Subject:
Page Index: 4
Date: 2/20/2024 4:48:20 PM
Author: Jeff Rice - EPC Engineering Review
Color: ■
Layer:
Space:
Page Label: 4

outfalls into an existing detention pond for the Meridian Ranch Development. This detention pond is located southwest of the proposed Eastonville Road Segment 1 Improvements. The existing detention basin capacity will be analyzed for the proposed improvements.

SCS DRAINAGE MAP MERIDIAN RANCH FILING 11A

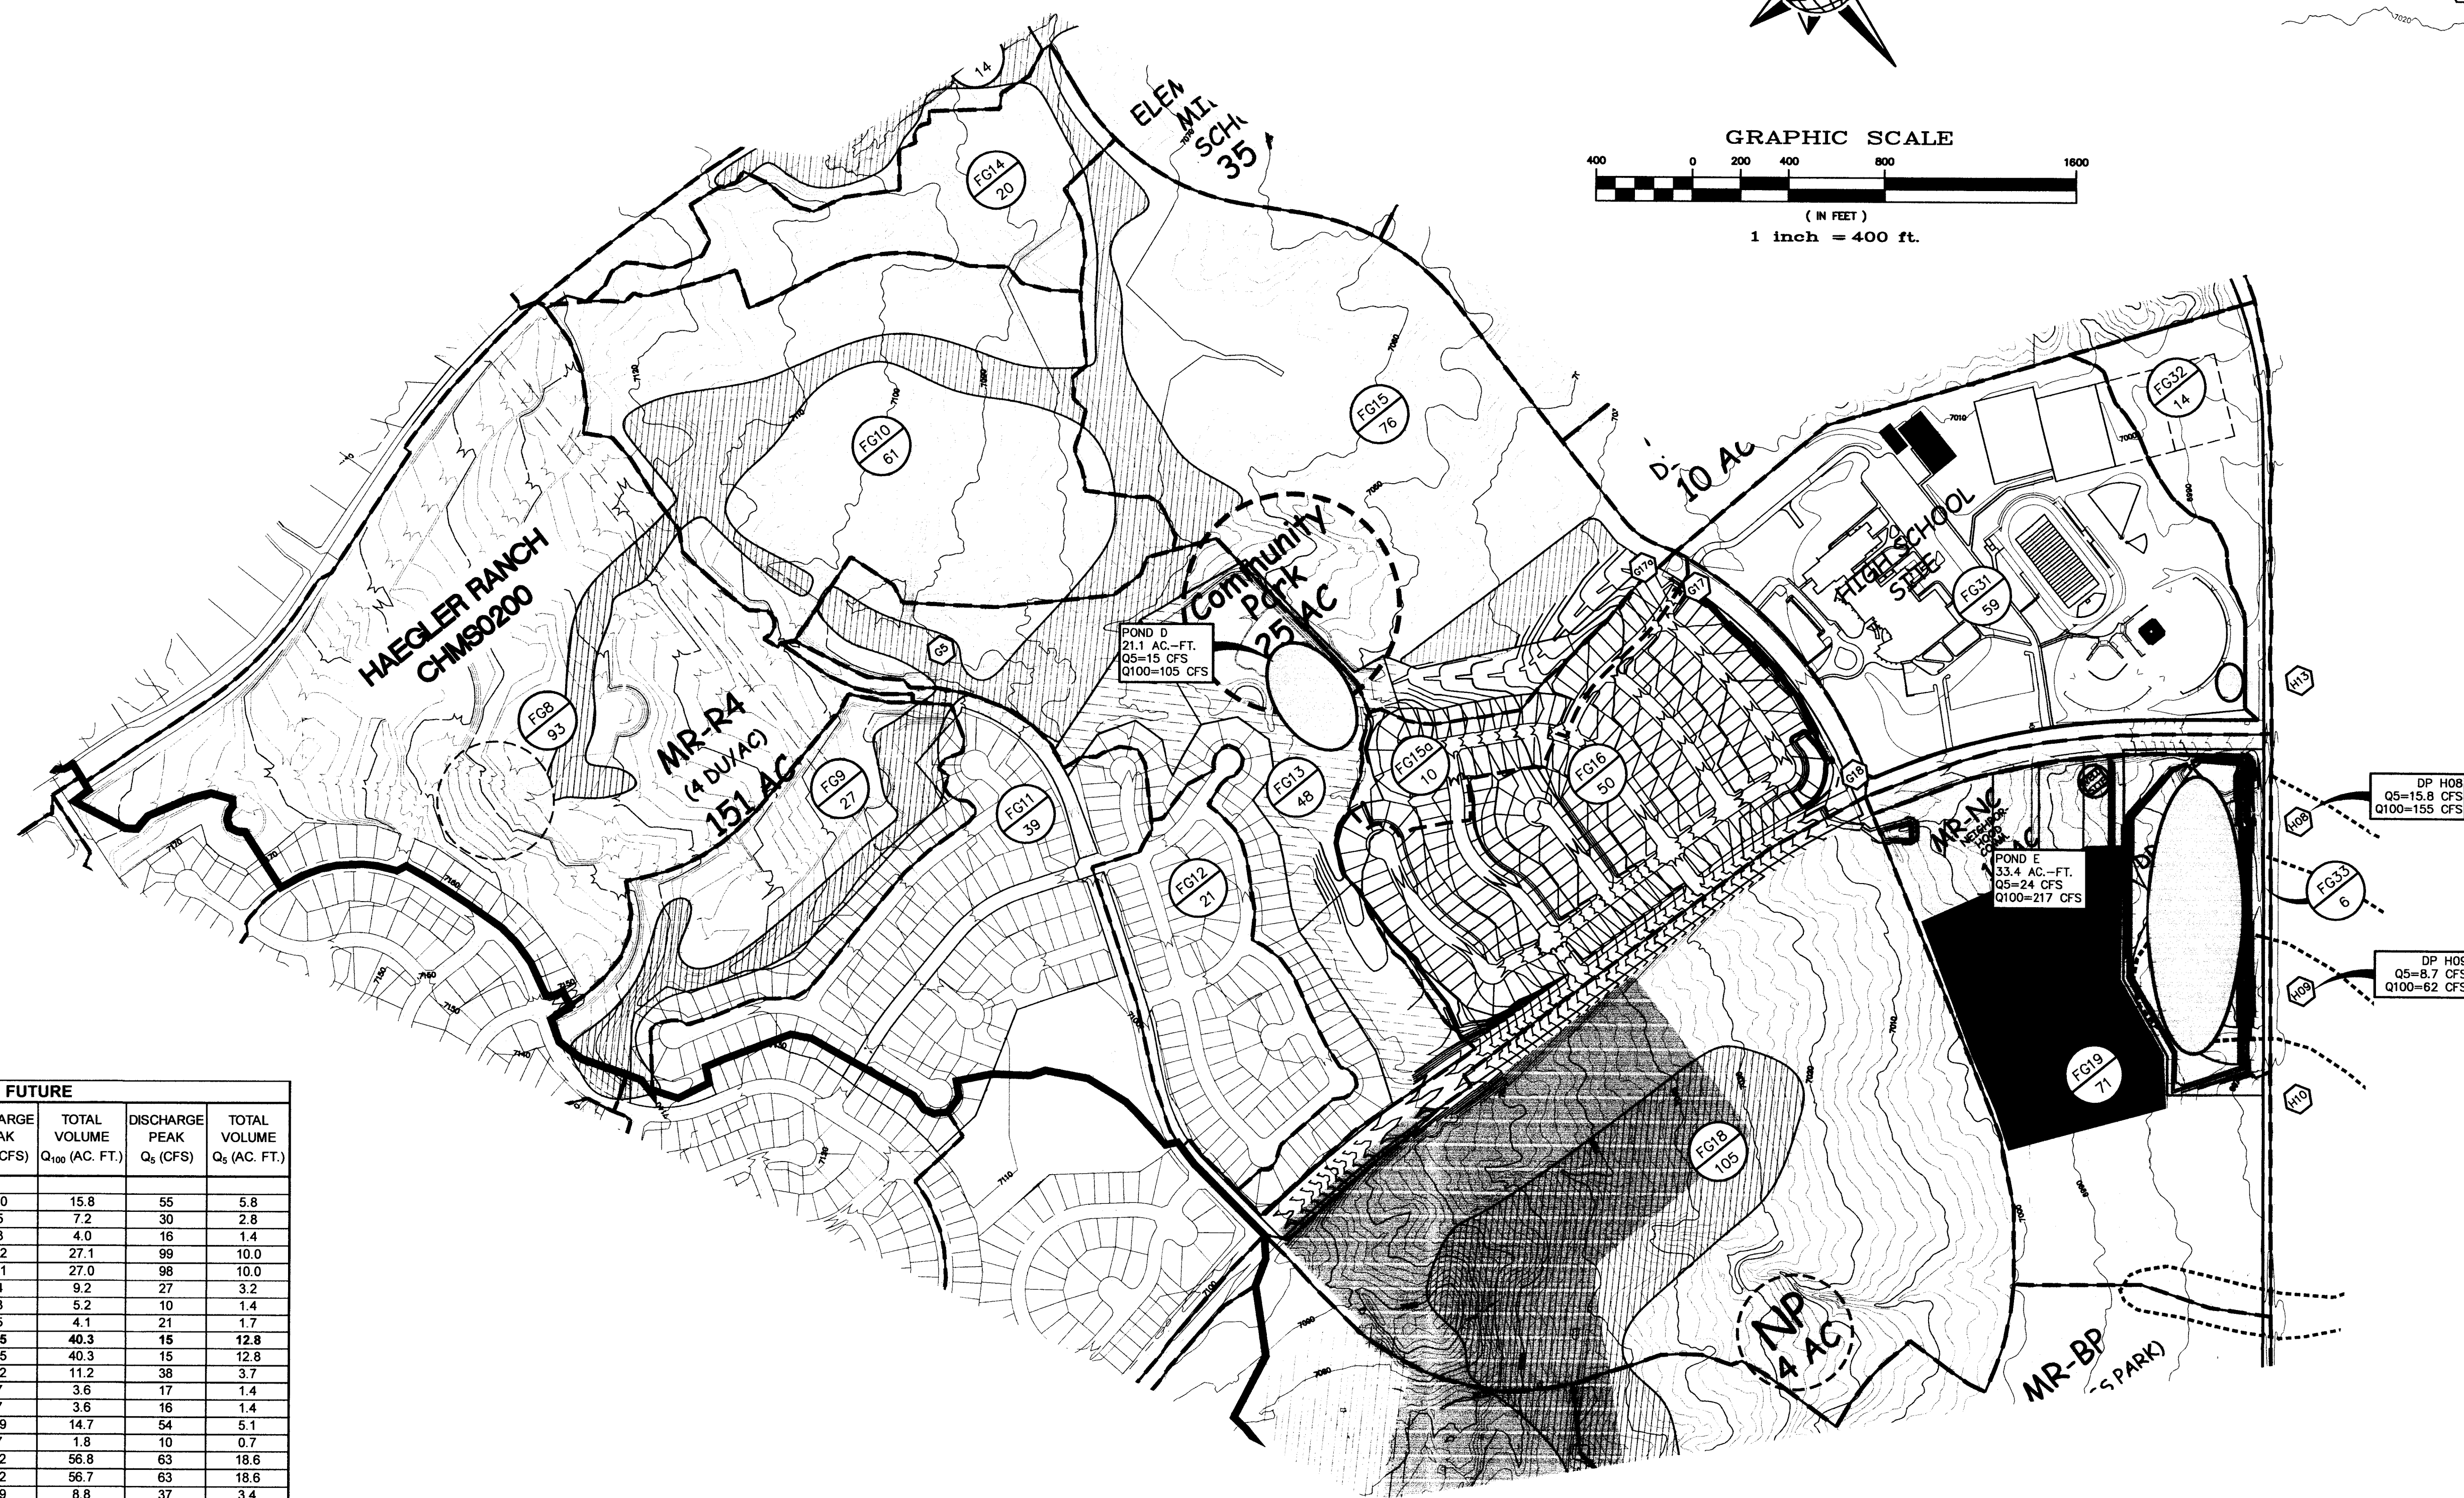
See MSMD comments for Meridian Basin. Full Spectrum EDBL.

Basins OS1, OS2, OS3, and the unnamed basins that are east of Eastonville Rd all have proposed soil disturbances within them, which all must be accounted for via WQ treatment or an applicable WQ exclusion. So please address this in the respective Basin paragraphs and create new proposed sub-basins as necessary.
